Ref 2241.corr.RVBC260619

2241 Winkley Hall Farm, Whalley Road, Hurst Green , BB7 9PN

Application references 3/2026/0094 and 0095

GENERAL NOTES

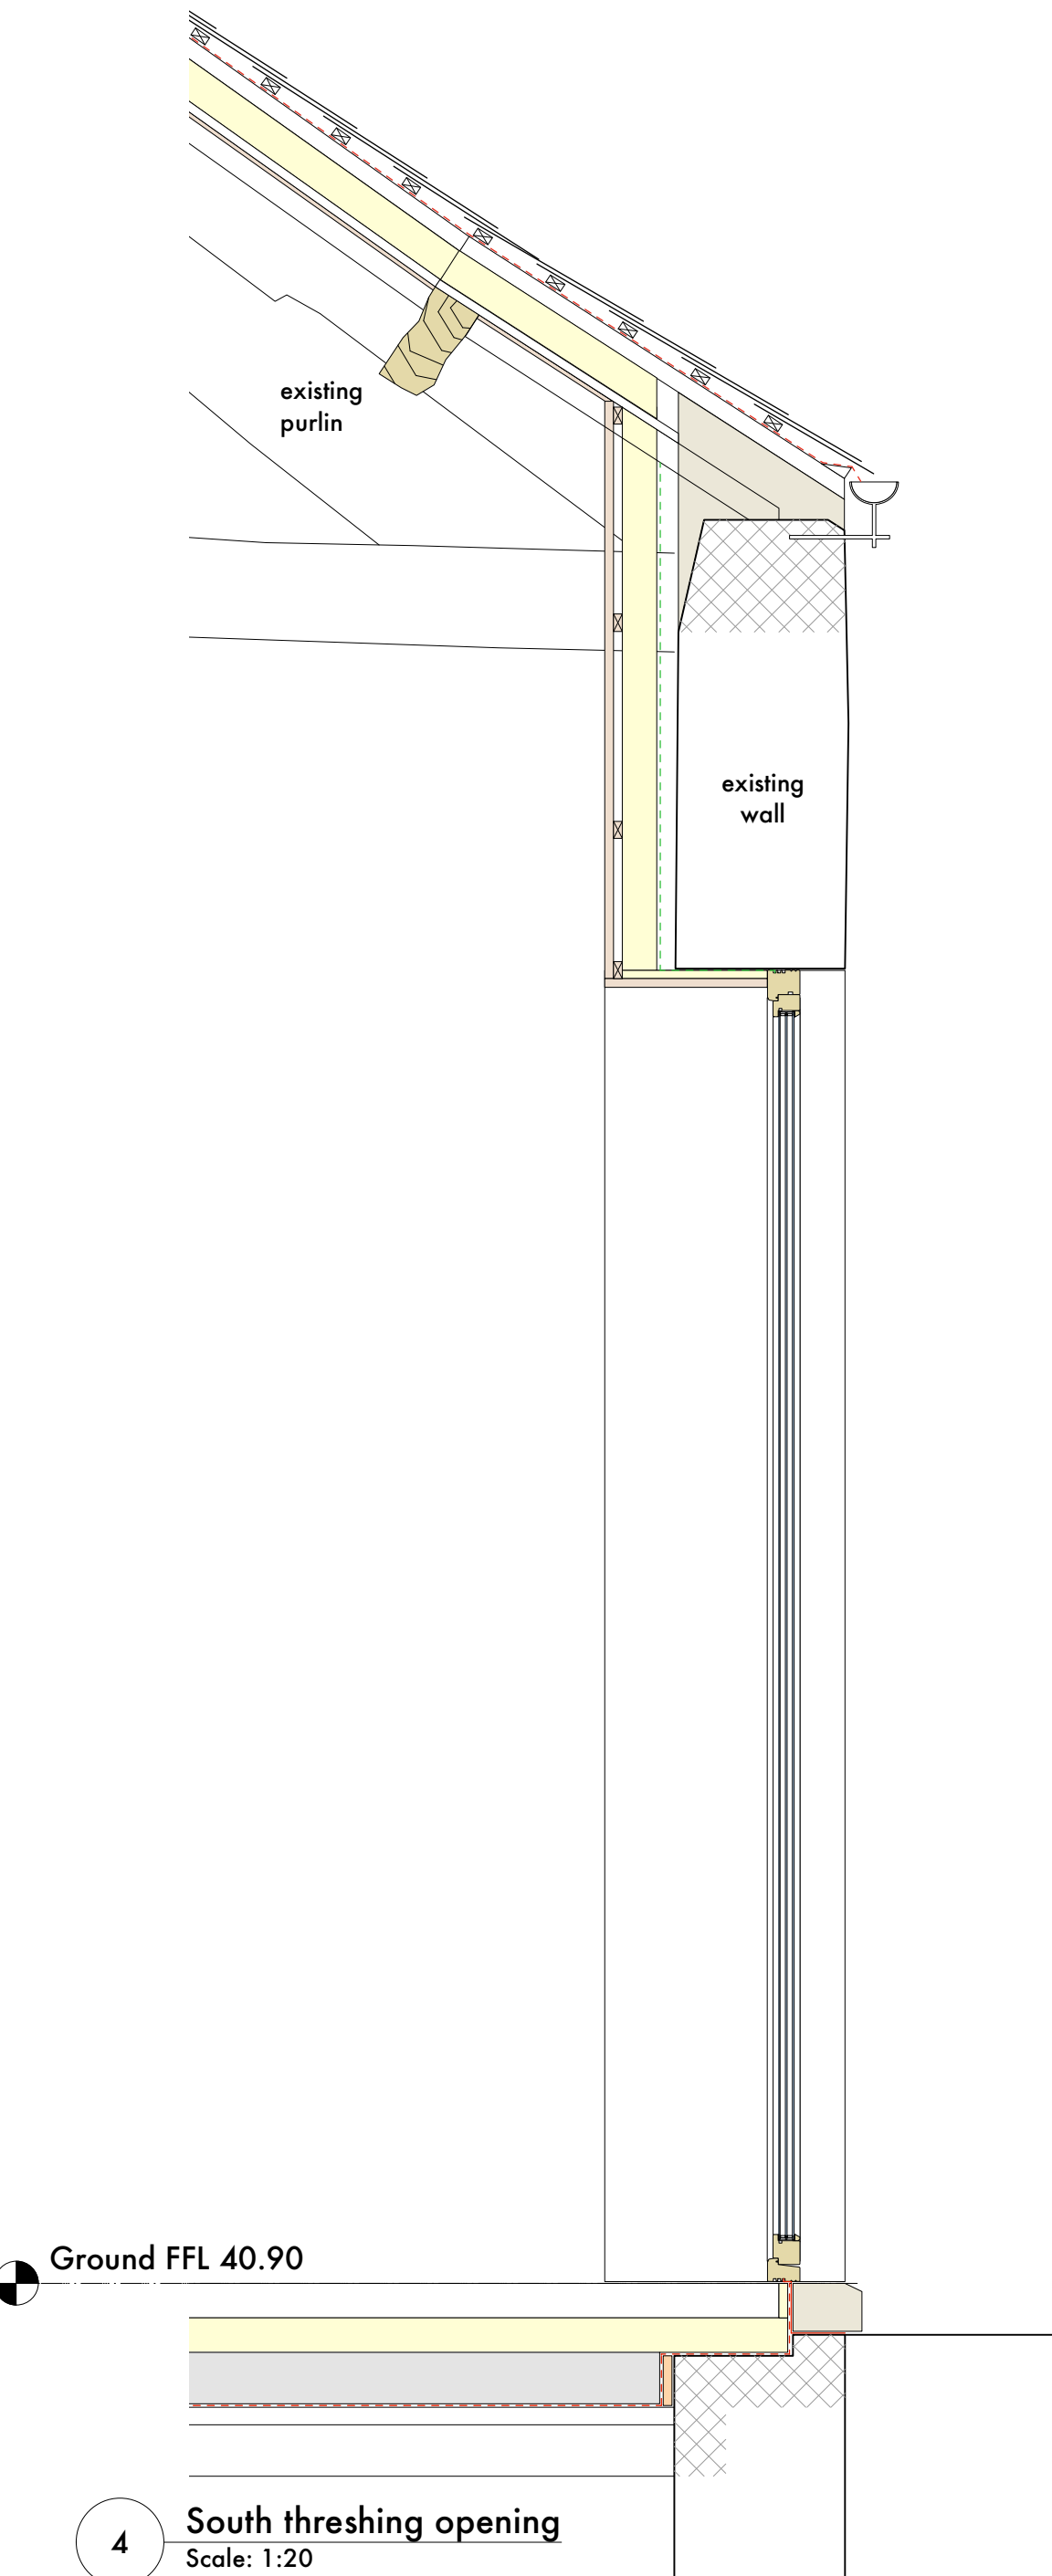
12. All floors are to be replaced with an insulated slab. The existing stone slabs to the threshing floor of the Main Barn are to be carefully lifted and re-used as part of the proposed floor finish. Illustrated to 111, 117, 118 and 120.

19. Full wall, floor and roof specifications included to 120 (Main Barn) & 220 (Barn 2). Independent stud linings proposed for walls to avoid disturbances to historic fabric where possible. Roofs will be insulated from above, leaving existing timbers (trusses, purlins, rafters etc) exposed internally.
